**Application no: 20/03619/F**

**Location:** Heyford Park, Camp Road, Upper Heyford

## **Drainage**

PHASE 9, HEYFORD PARK - ATTENUATION BASIN LOCATION PLAN

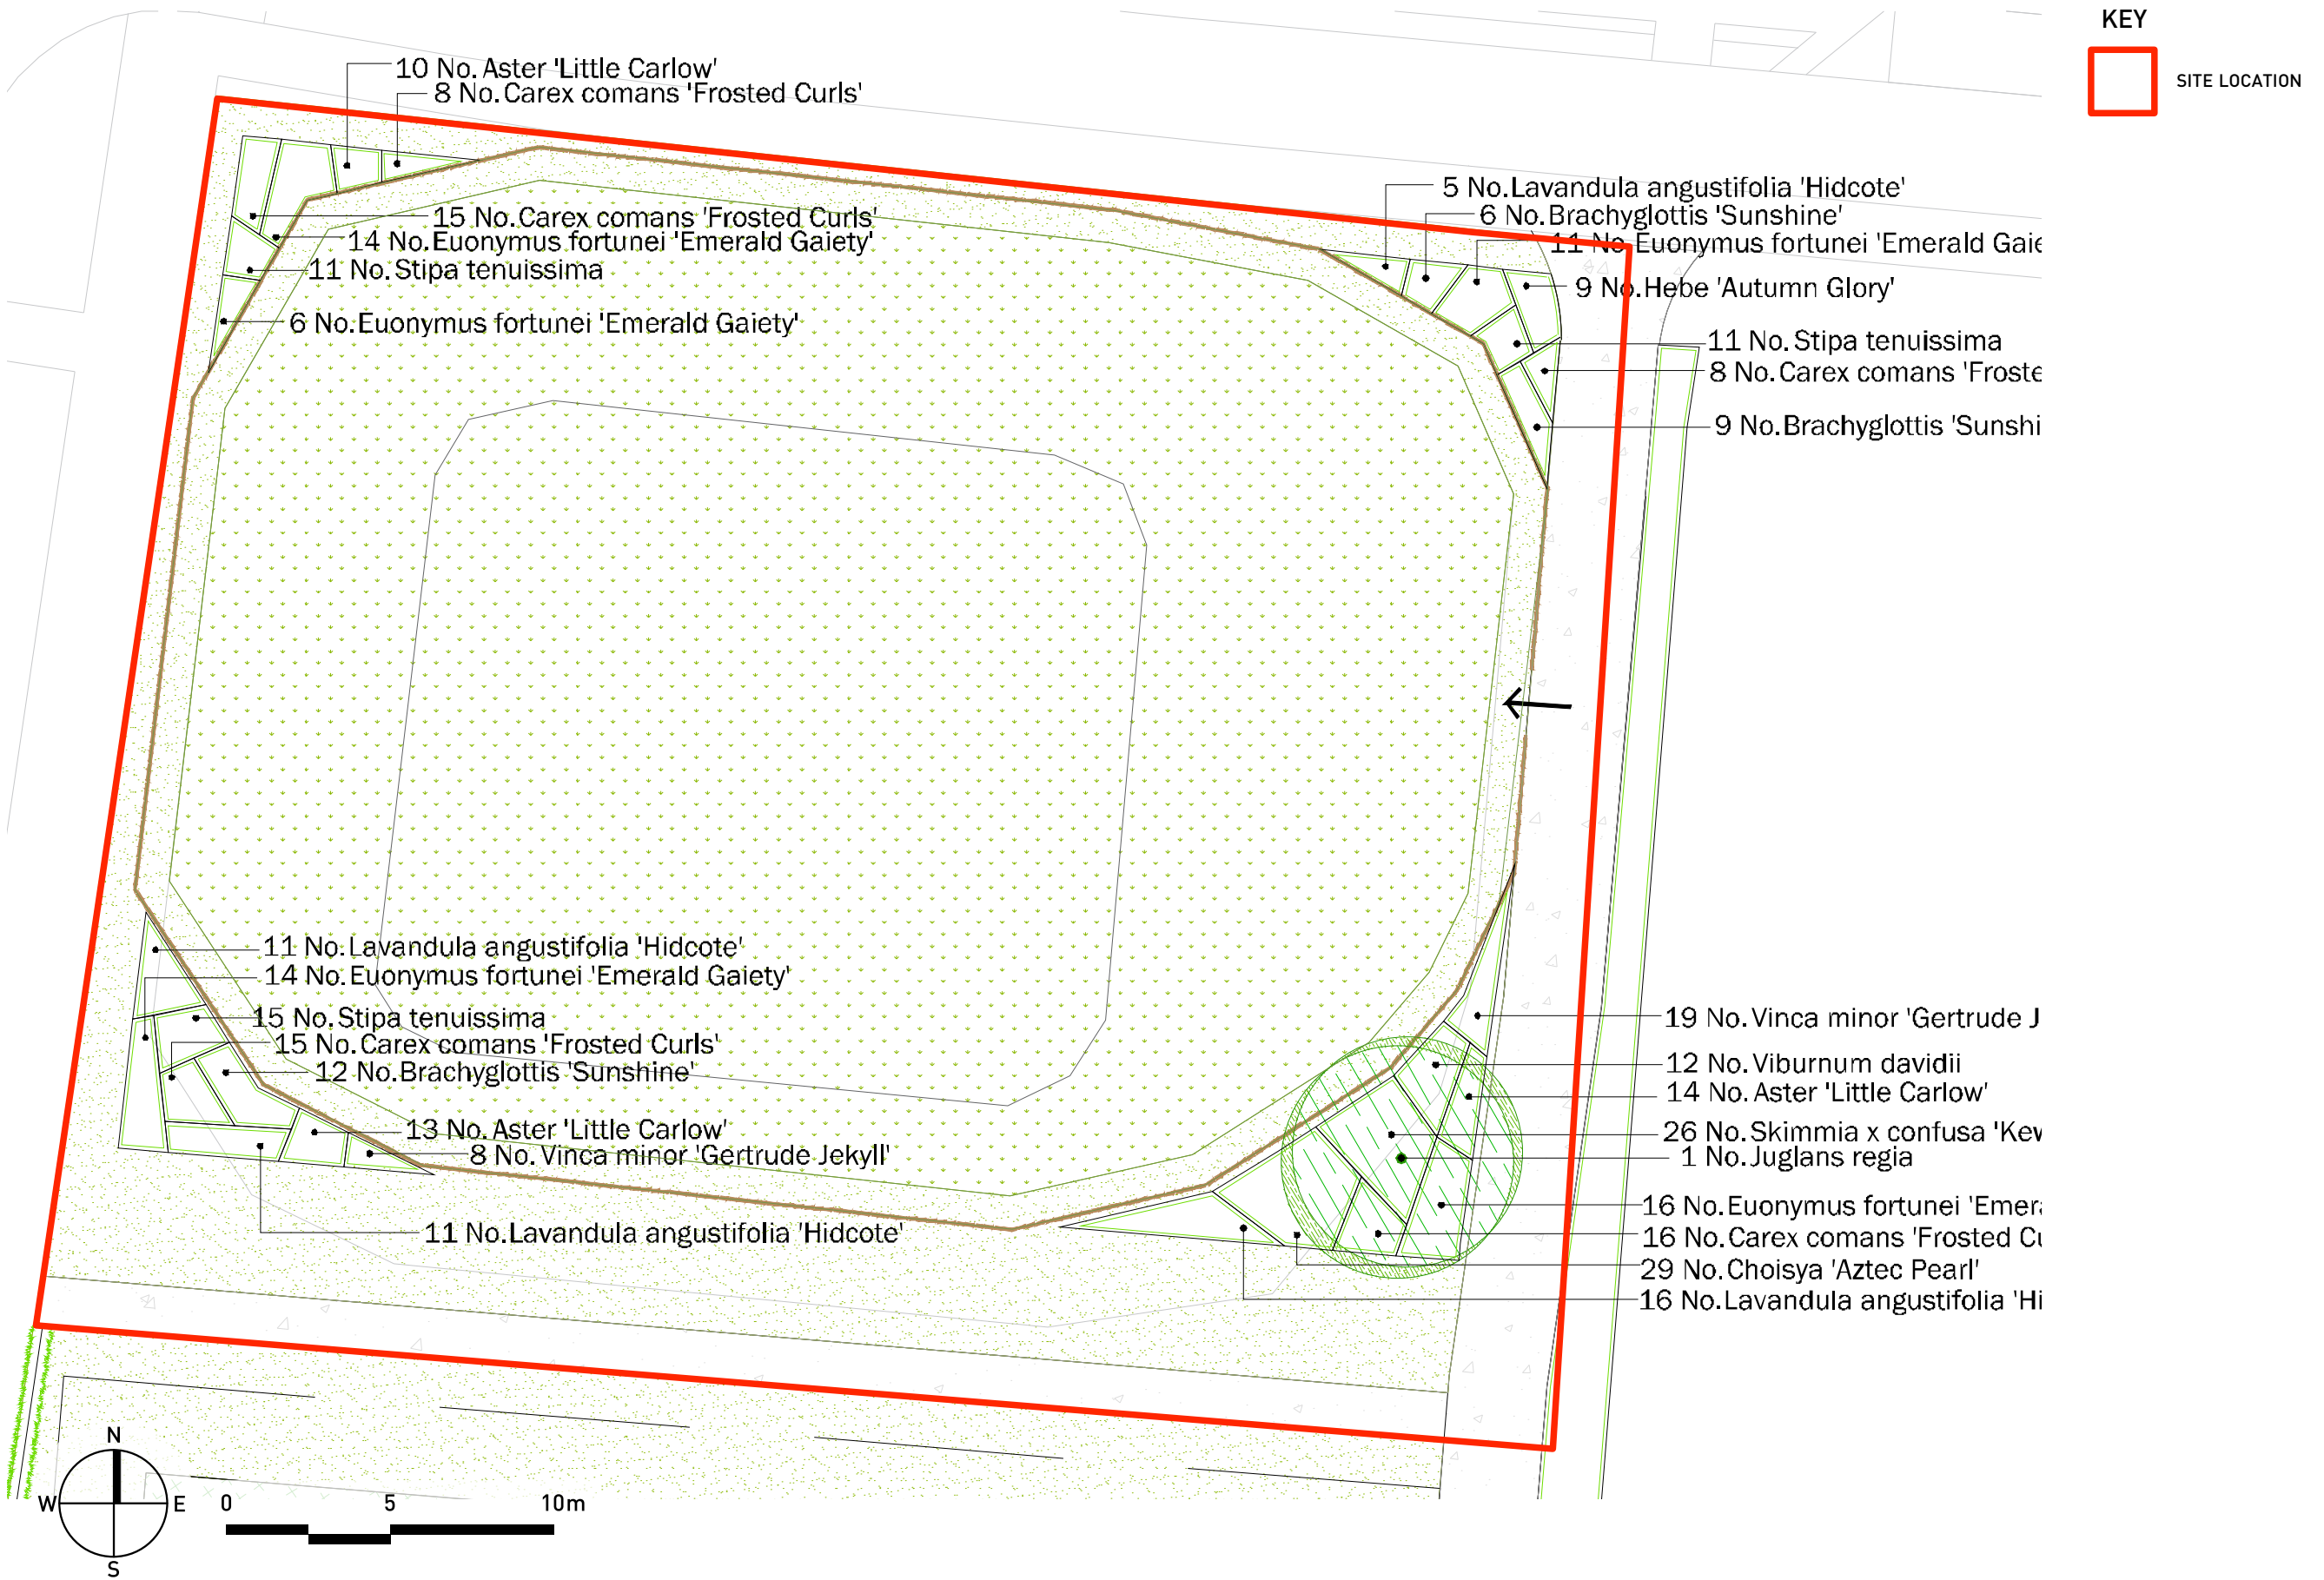
The attenuation basin TWL during the 100y+30% event is 122.377mAOD with the GL of 123.090, there is sufficient freeboard and is likely to be ok during the +40%cc event but needs checking.
